**Consultation Response from KC,  
Highways Development Management****2023/92103 Dixon Hall And Co Ltd, Grafton Street, Batley, WF17 6AR****Prior notification for change of use from offices to 6 dwellings****Date Responded: 21-8-2023.****Responding Officer: Mark Berry****Responding Ref: 15-4SE-14.**

Prior notification for change of use from offices to 6 one bedroomed apartments at Dixon Hall and Co Ltd, Grafton Street, Batley.

TITLE: SWEPT PATH ANALYSIS
STANDARD DESIGN VEHICLE (CAR)

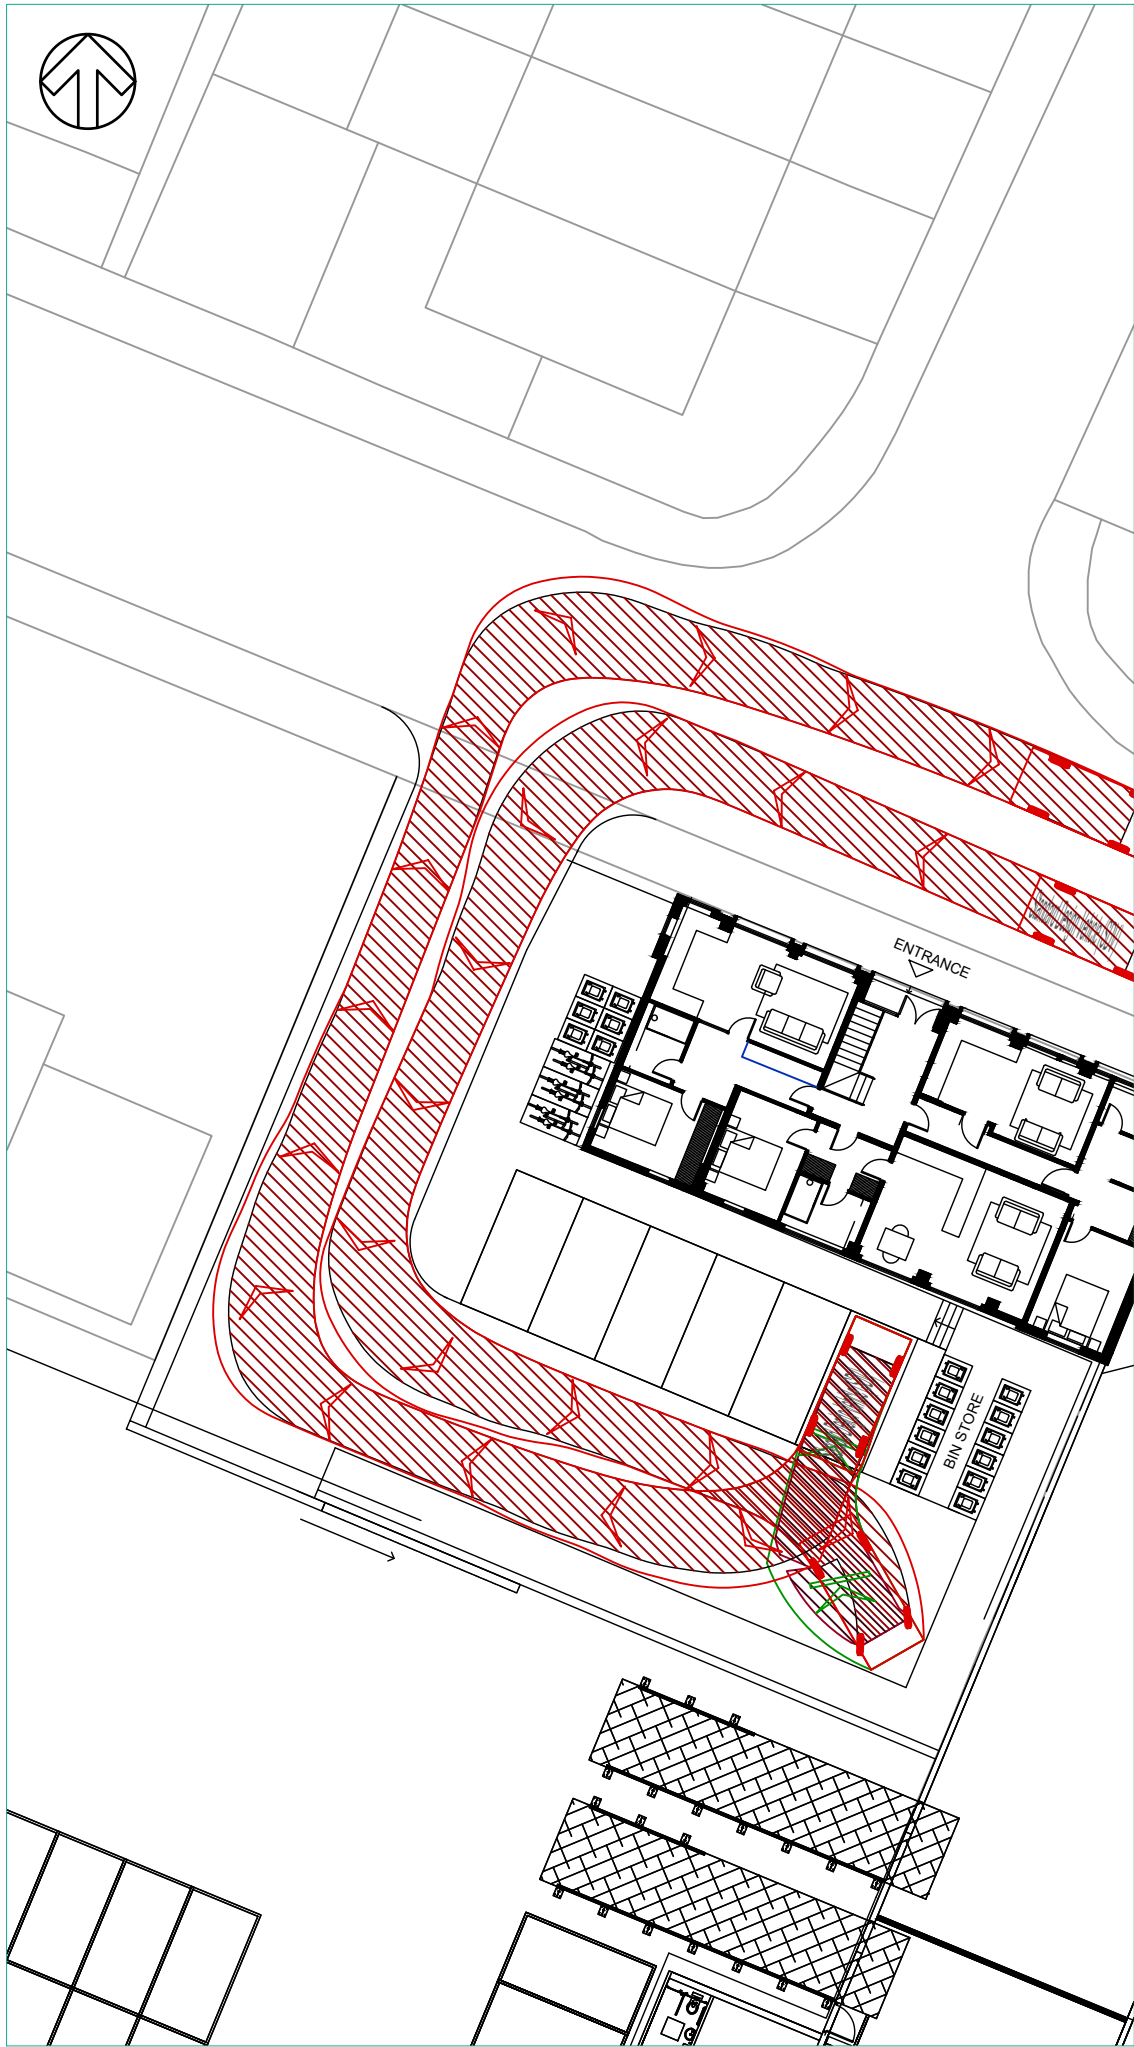
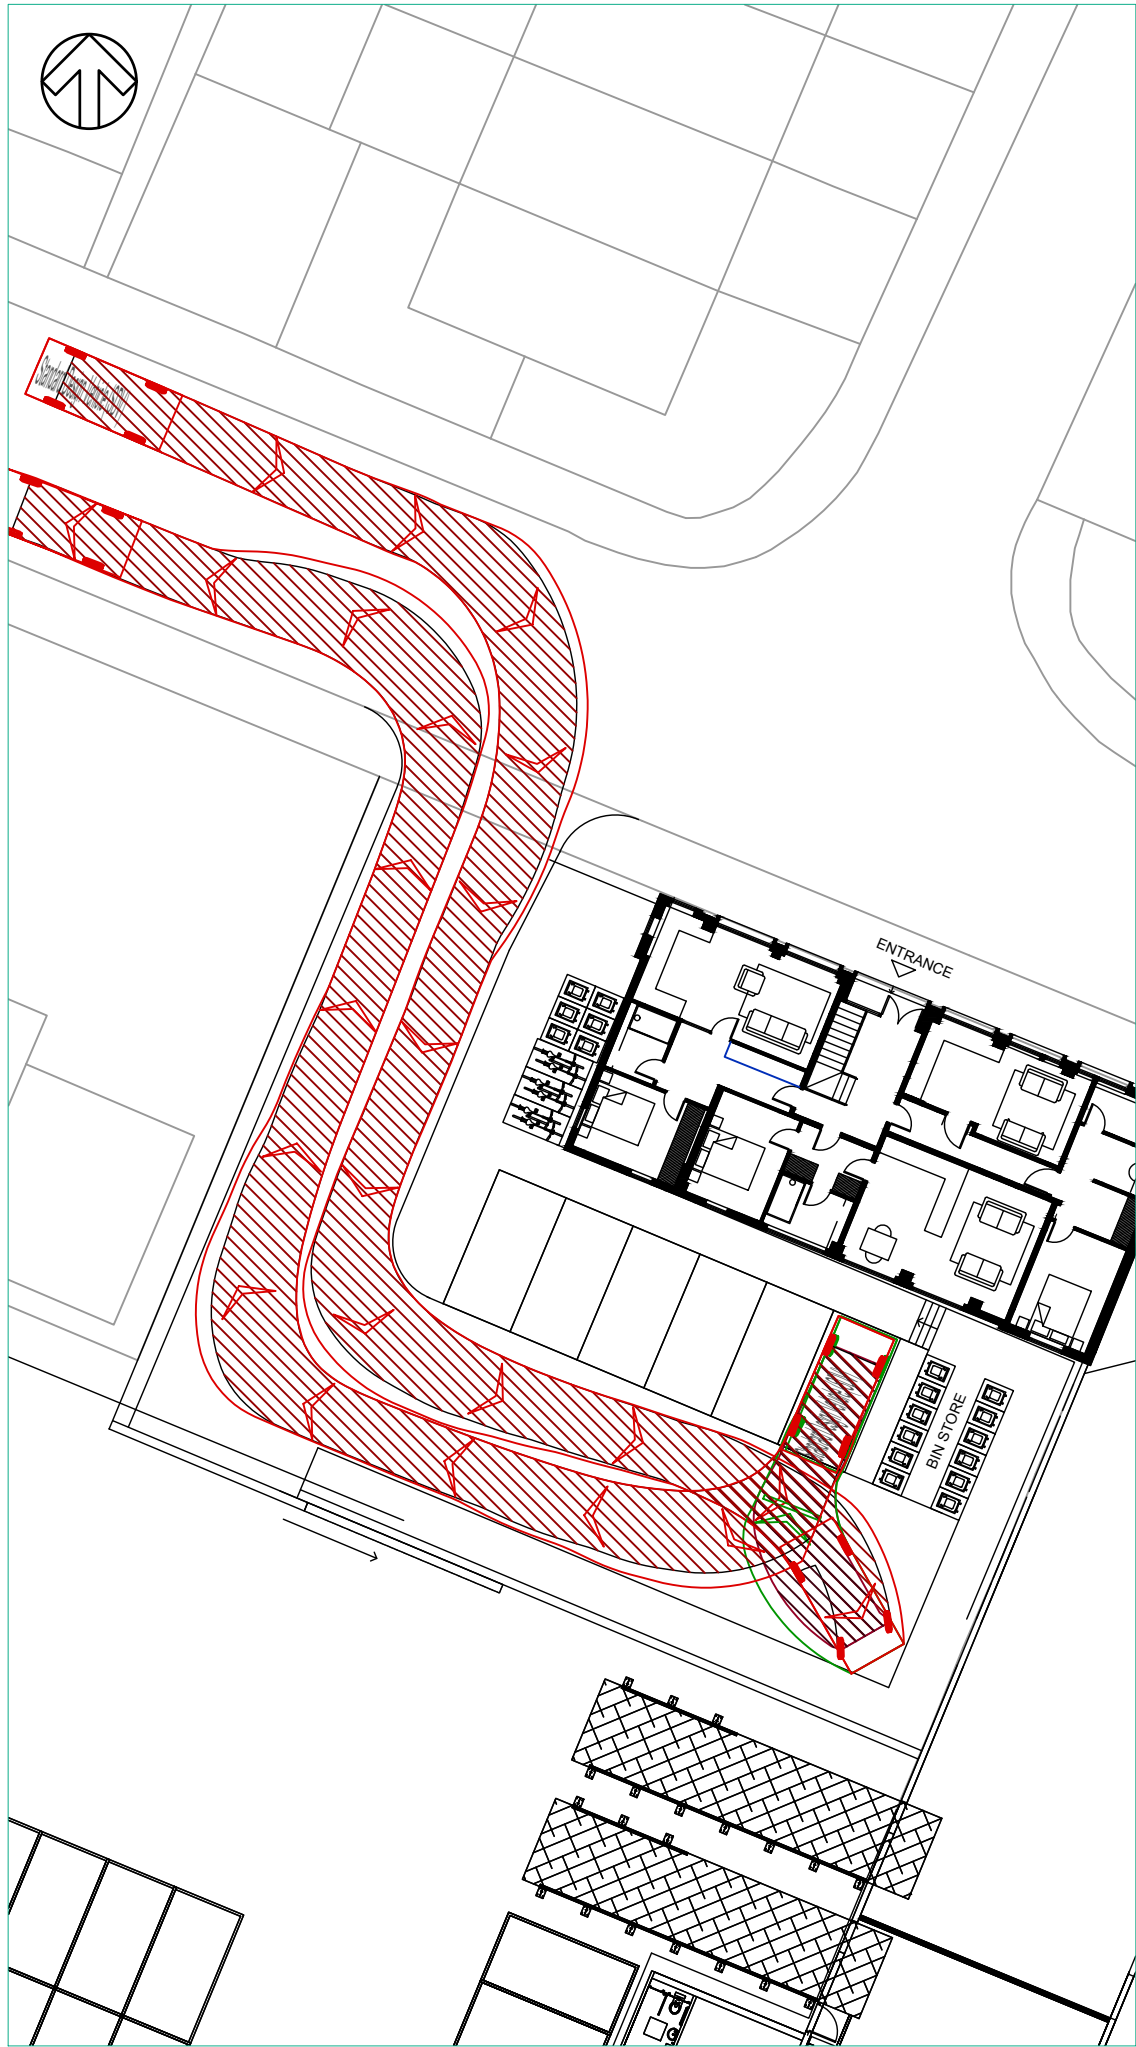
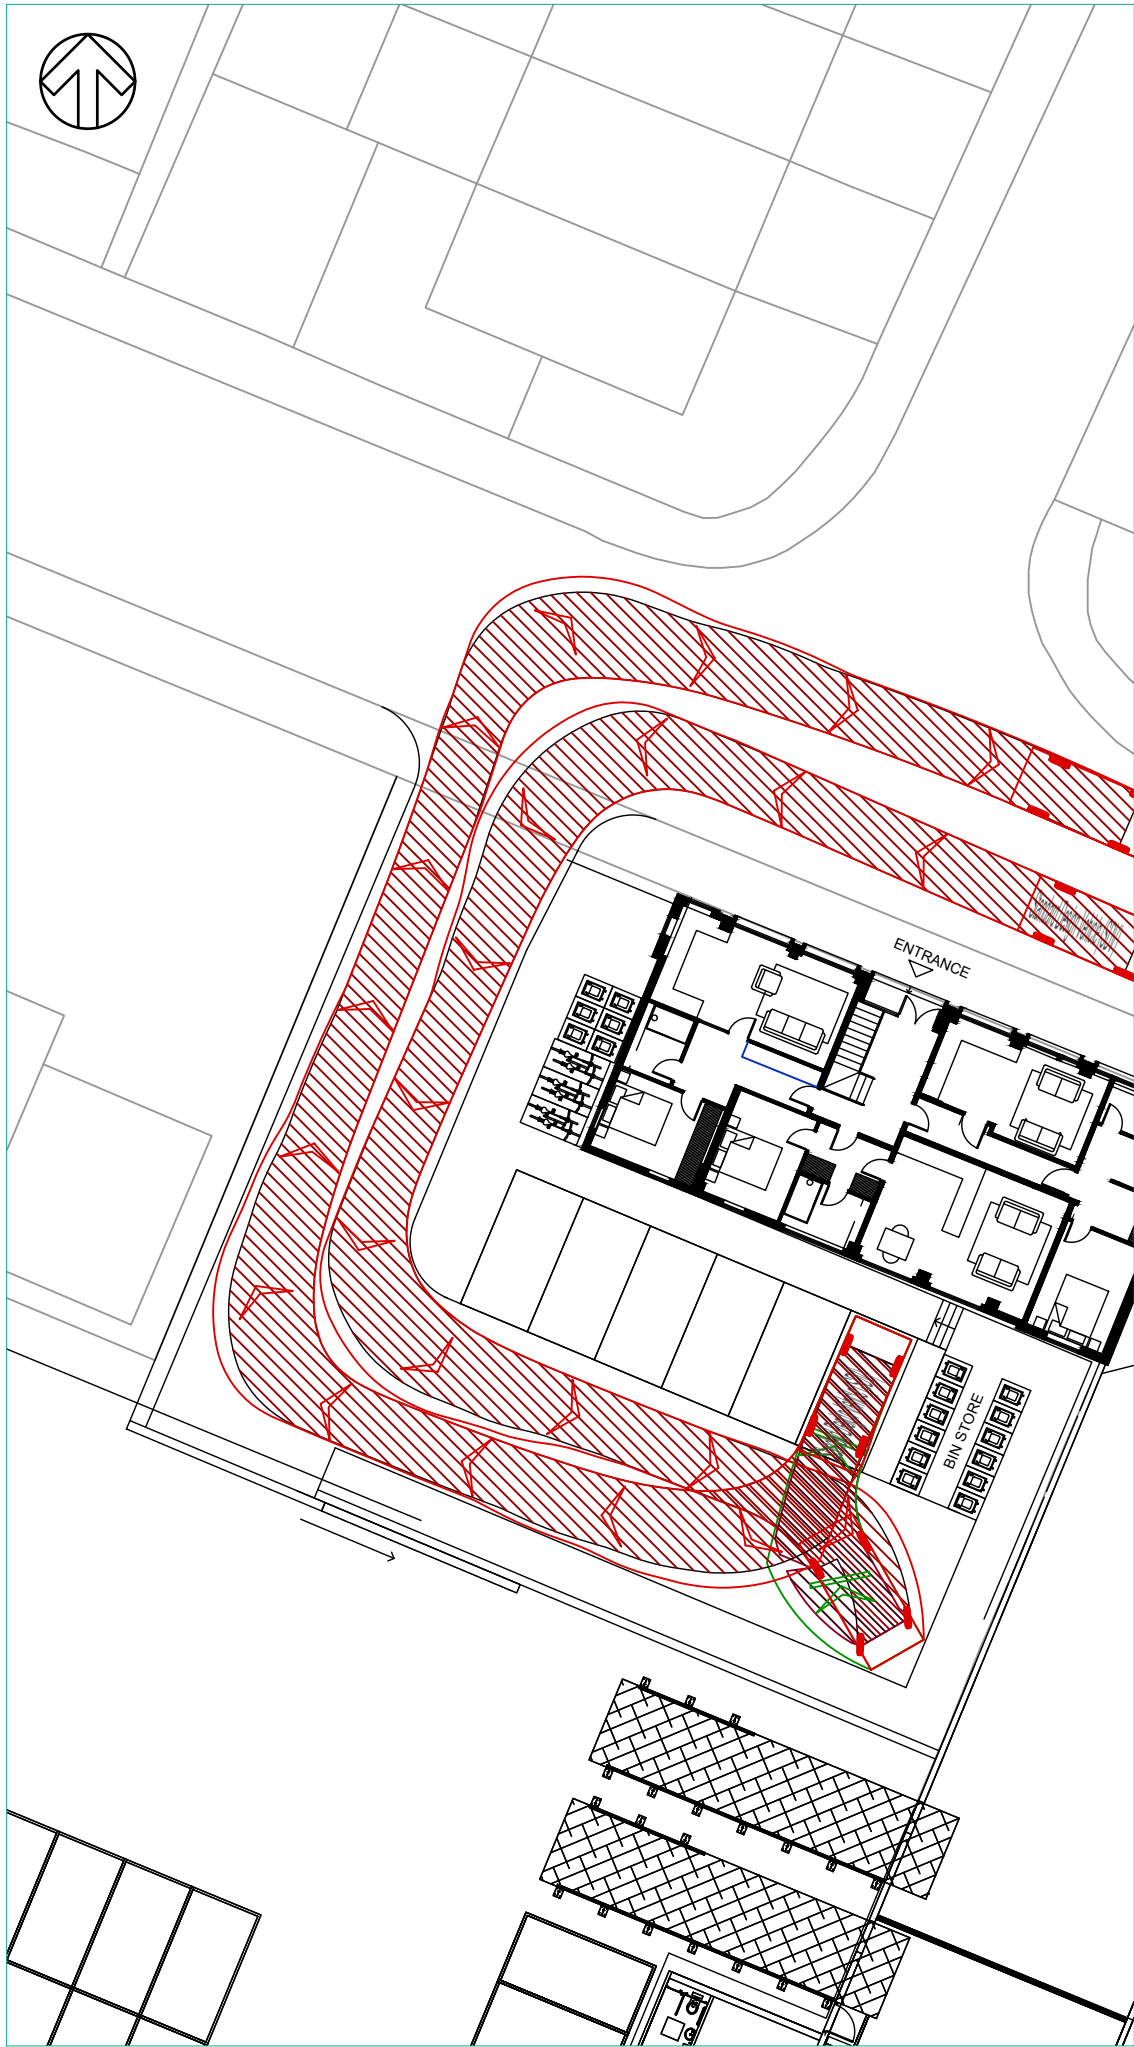
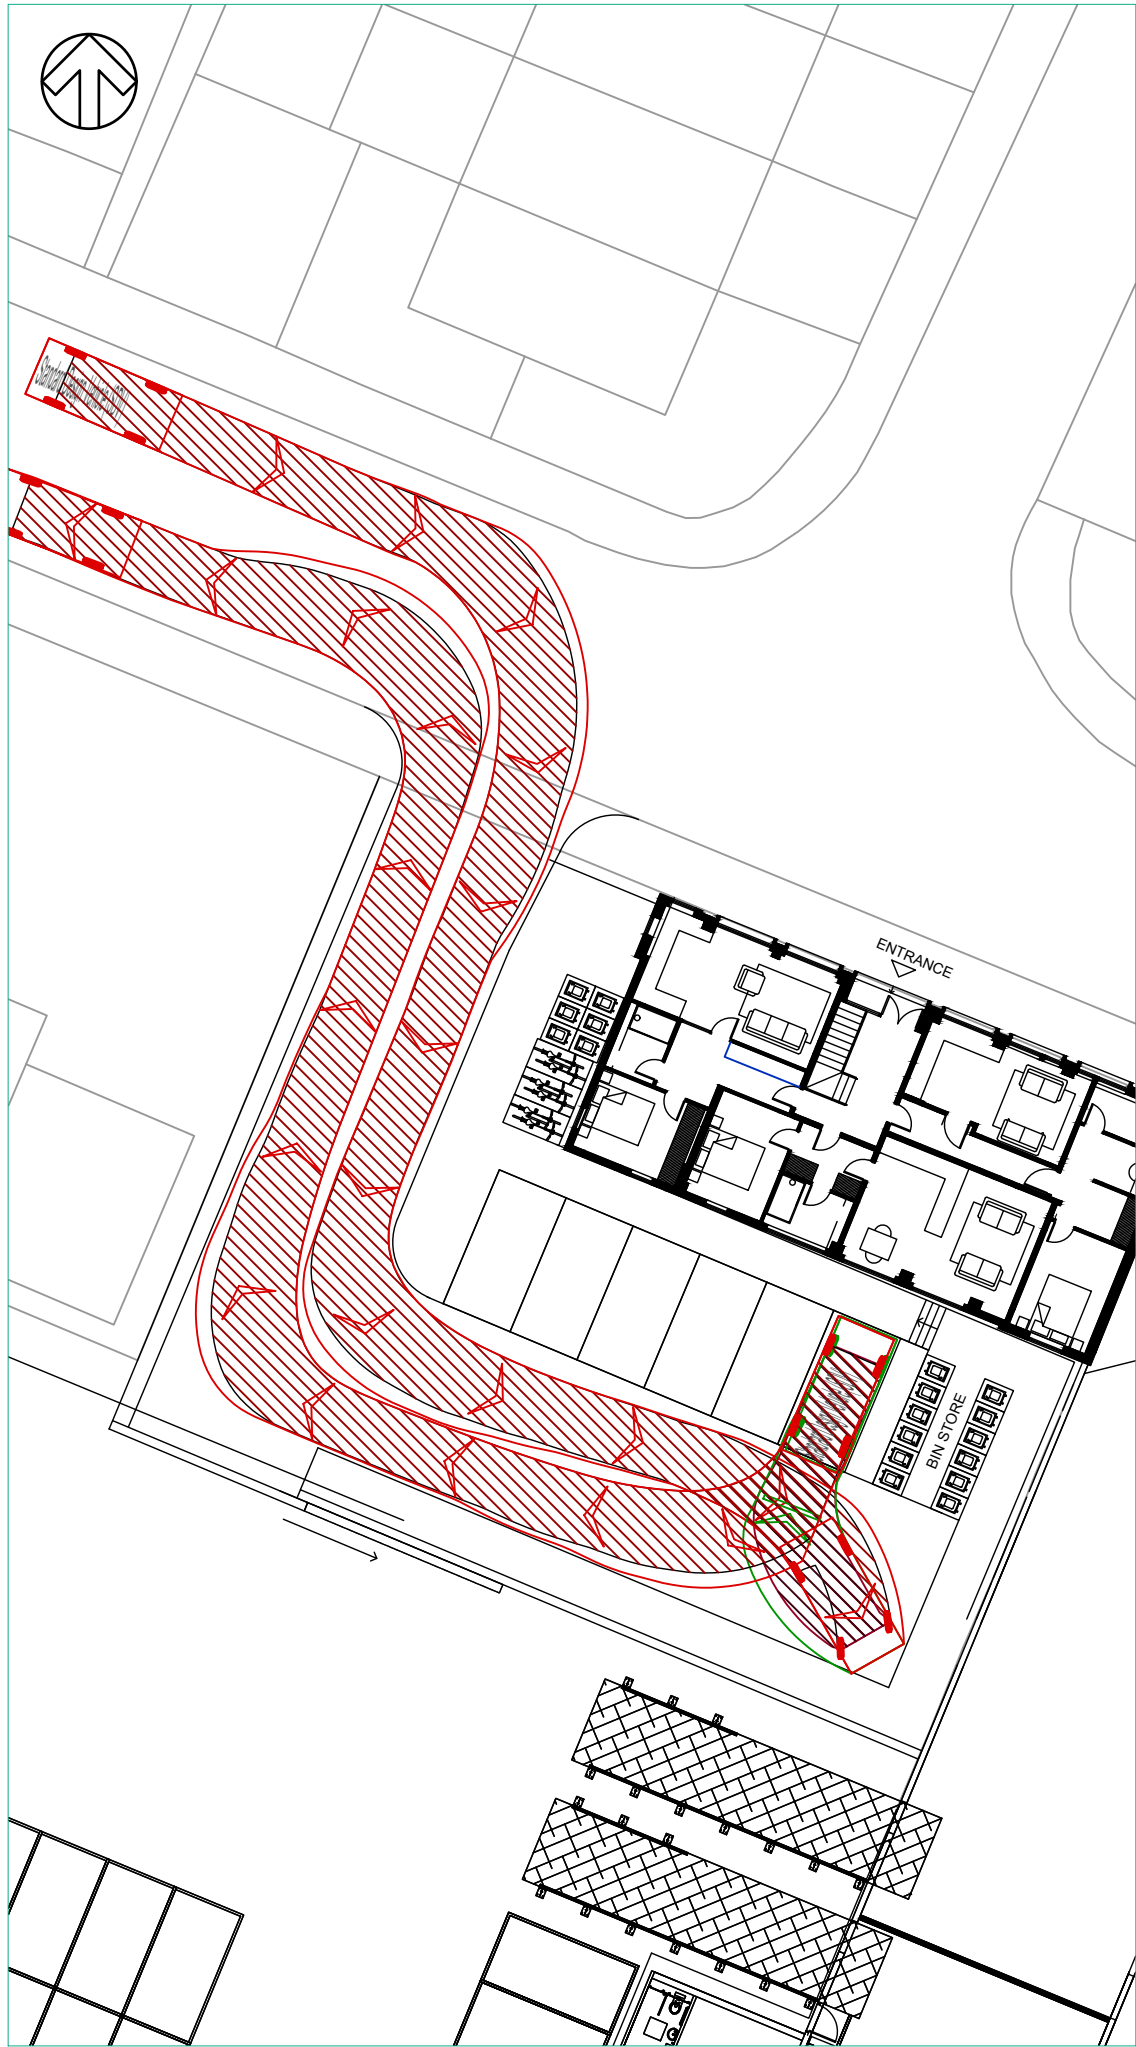
2, The applicants should demonstrate that the loss of off-street parking and service yard to residential use still allows sufficient space for HGV access and internal vehicle turning and that that sufficient off-street parking is retained to the remaining 'Dixon Hall Tools' industrial site.

3, The applicants should demonstrate that good visibility is provided between vehicles exiting the proposed parking area and vehicles exiting the access to the remainder of the 'Dixon Hall Tools' industrial site via the sliding gate.
